Representations on the A66 Northern Trans-Pennine Project

Submitted on Behalf of Mr P White

18th December 2022

Drawing Title  
**Land Plans  
Regulation 5(2)(i)  
Sheet 5 of 7**

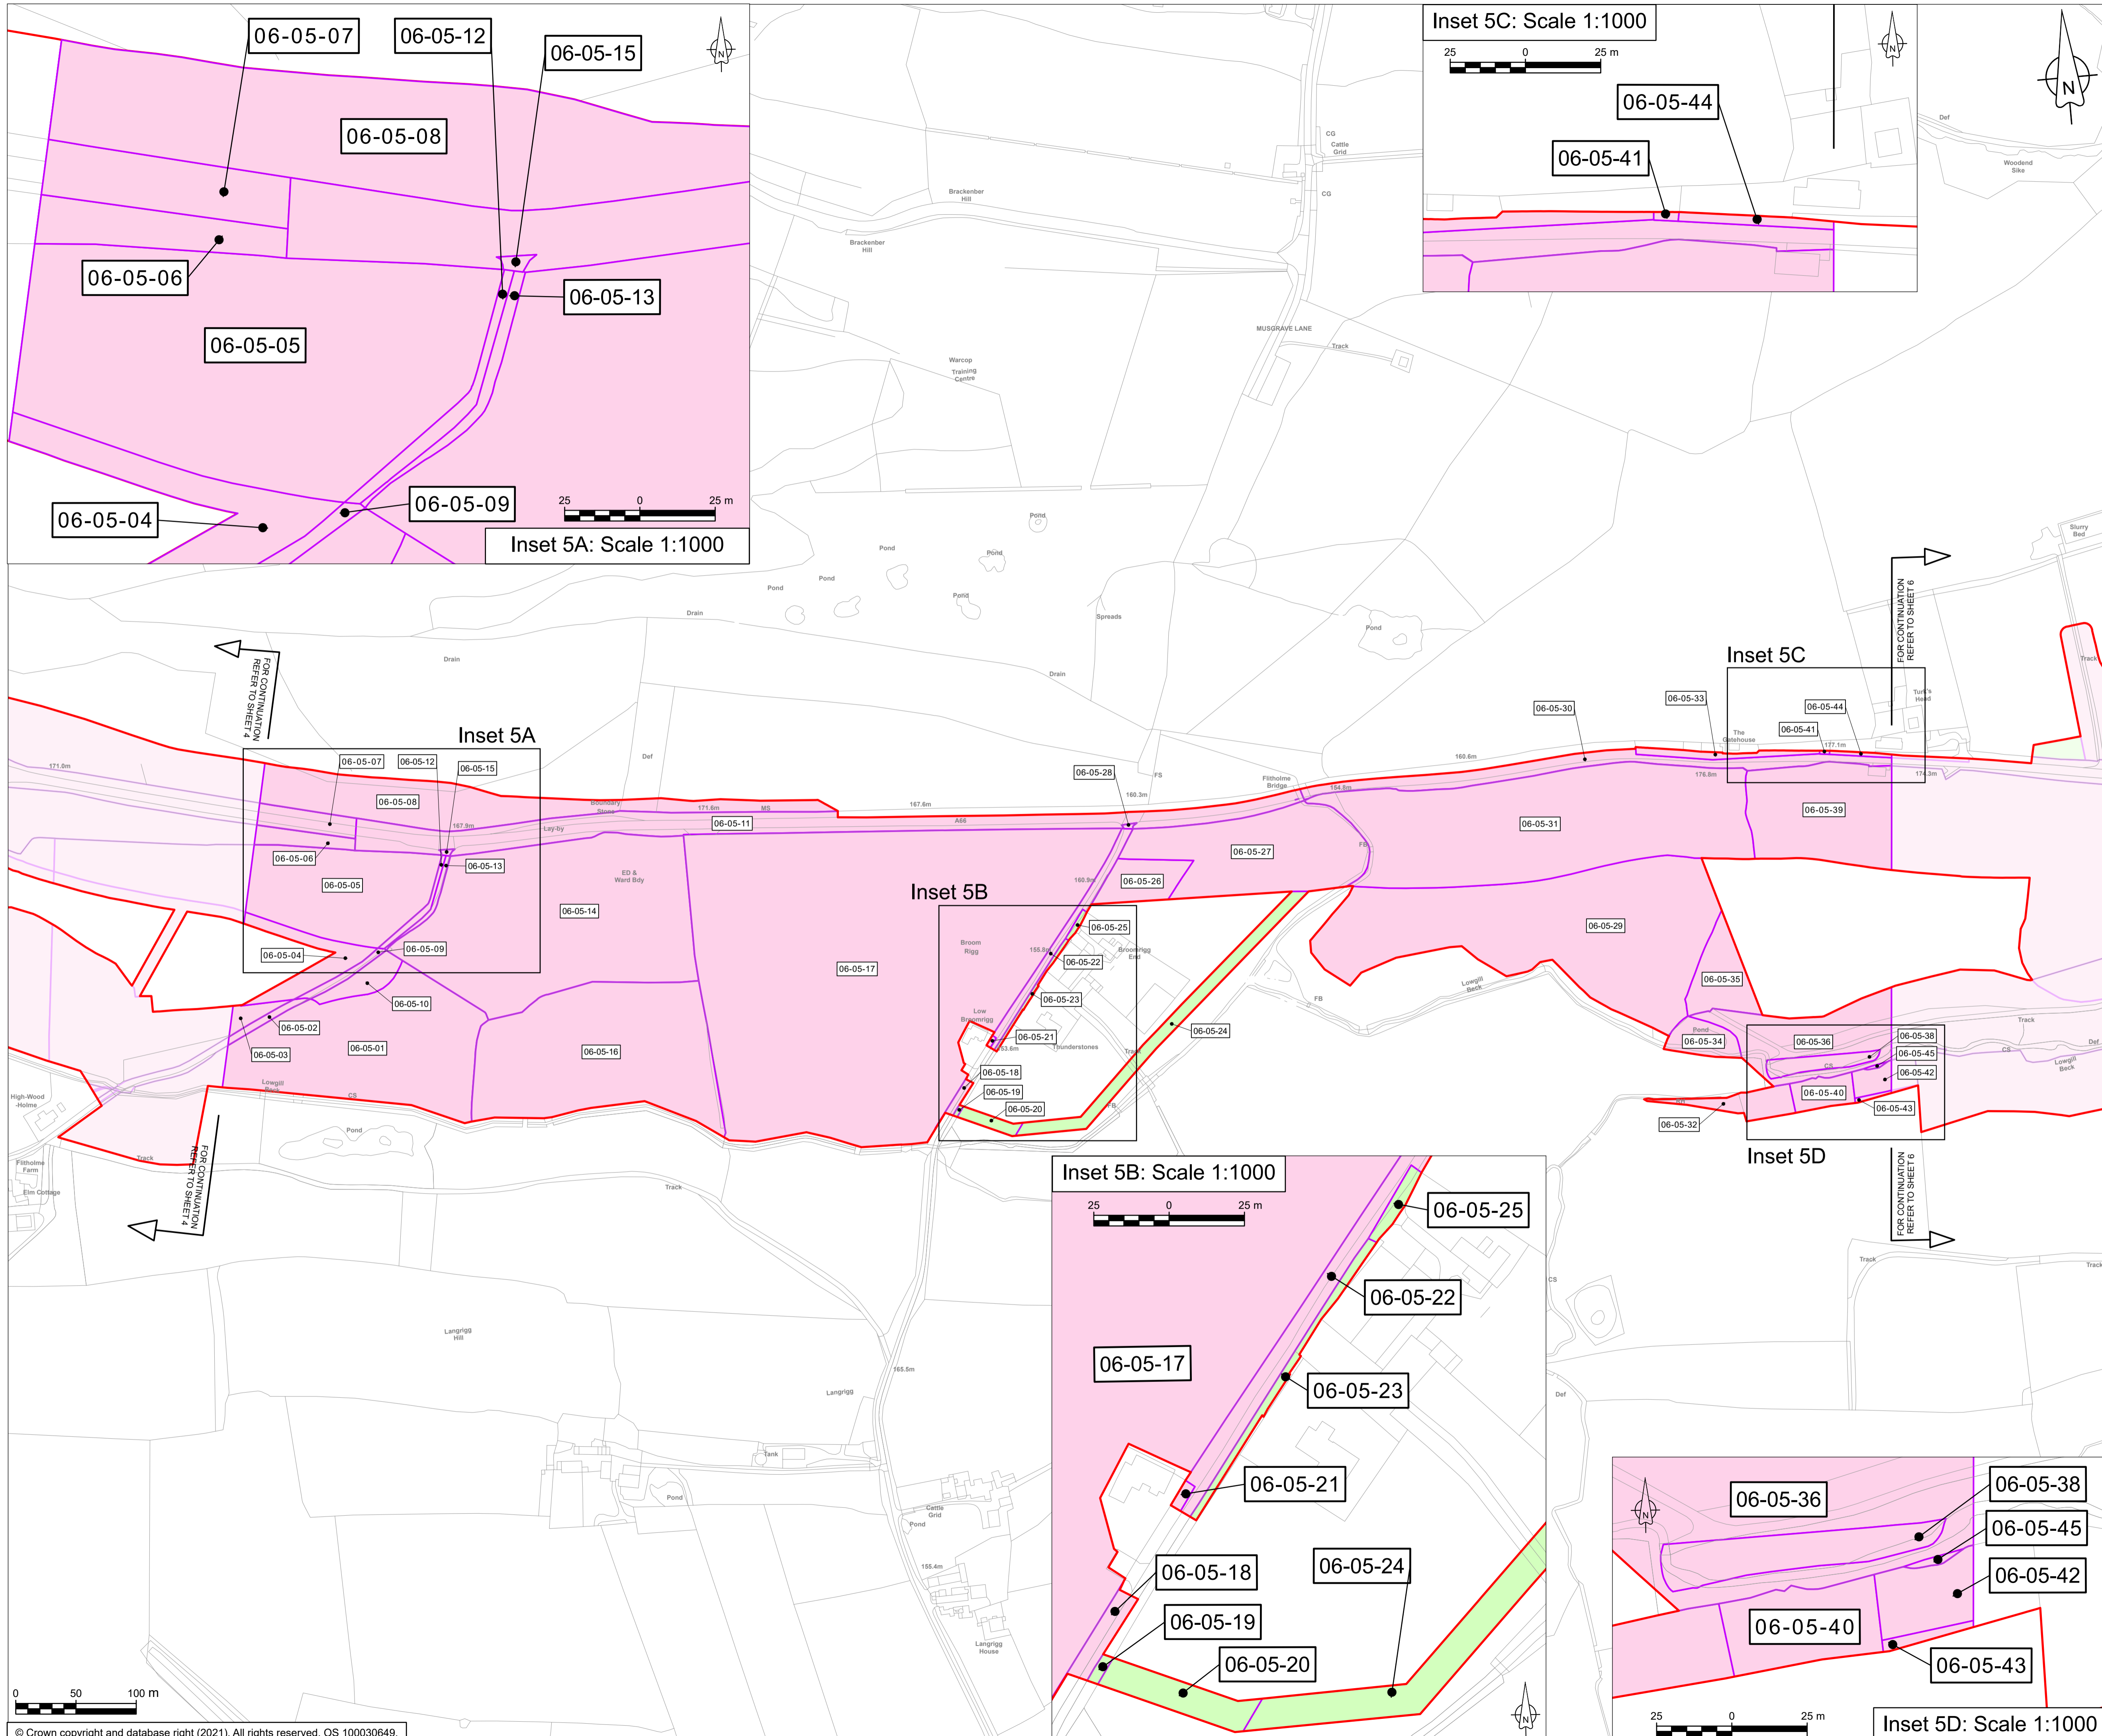
07-02-68, 07-02-71, 07-02-96, 07-02-99

2.4.1 As previously advised to the Applicant, the land where the proposed pond is due to be positioned is in-fill land. We cannot be certain what the land was filled with and we cannot rule out that it was not filled with hazardous material. Taking into account the point made above in relation to the importance of the land to Mr White, if there are more suitable/safer locations for the pond elsewhere then we would urge the Applicant to consider them.

2.4.2 We are also concerned that the proposed pond will not mitigate the flooding on the existing old A66, as the proposed site of the pond is on a raised piece of in fill ground.

2.4.3 Given the size of the proposed pond to the North, we would also ask whether the proposed pond to the South is necessary. We note that the land to the north is somewhat lower.
